**Summary of Representations made at ISH4 submitted by National Highways Limited**  
**Application by London Luton Airport Limited for an Order granting Development Consent for the**  
**London Luton Airport Expansion Project**

**Planning Inspectorate Reference Number: TR020001**

Figure 4 - An extract from the interventions's drawing M1J10-NB-A-01

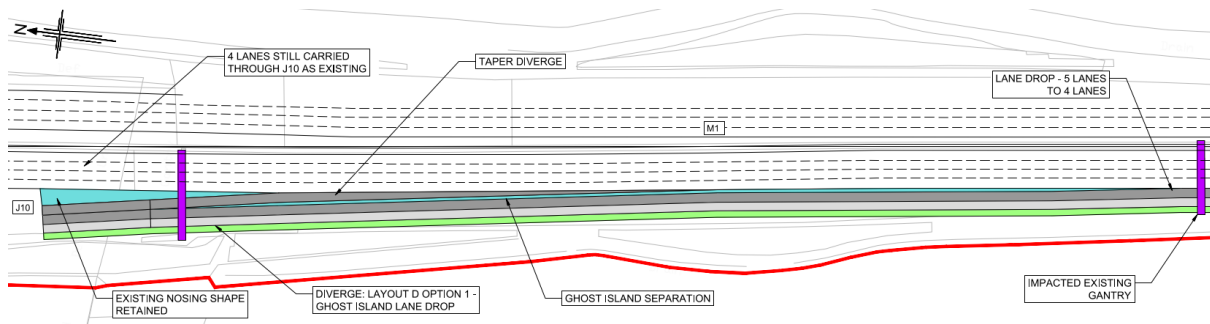
- 4.2 Due to the recent change by the Applicant to exclude the All Lane Running scheme from the traffic modelling, it is not clear what mitigation is being proposed for phase 2b of the M1 Junction 10 works. Phase 2b currently shows improvements to the slip roads, however this proposed mitigation would tie into the All Lane Running scheme, which is no longer being delivered. National Highways is unclear whether the mitigation for phase 2b no longer includes the slip road mitigation. If this is removed, then the Vissim modelling will need to be updated to confirm the impact of the reduction in capacity on the slip roads.

- 4.4 National Highways will issue Technical Note M1J10\_TN\_01 Final to the ExA, which sets out the extent of further mitigation required on the slip roads at M1 Junction 10 to mitigate the forecast congestion and provides a high level design solution. This information was issued to the Applicant's consultants on 13 September 2023.
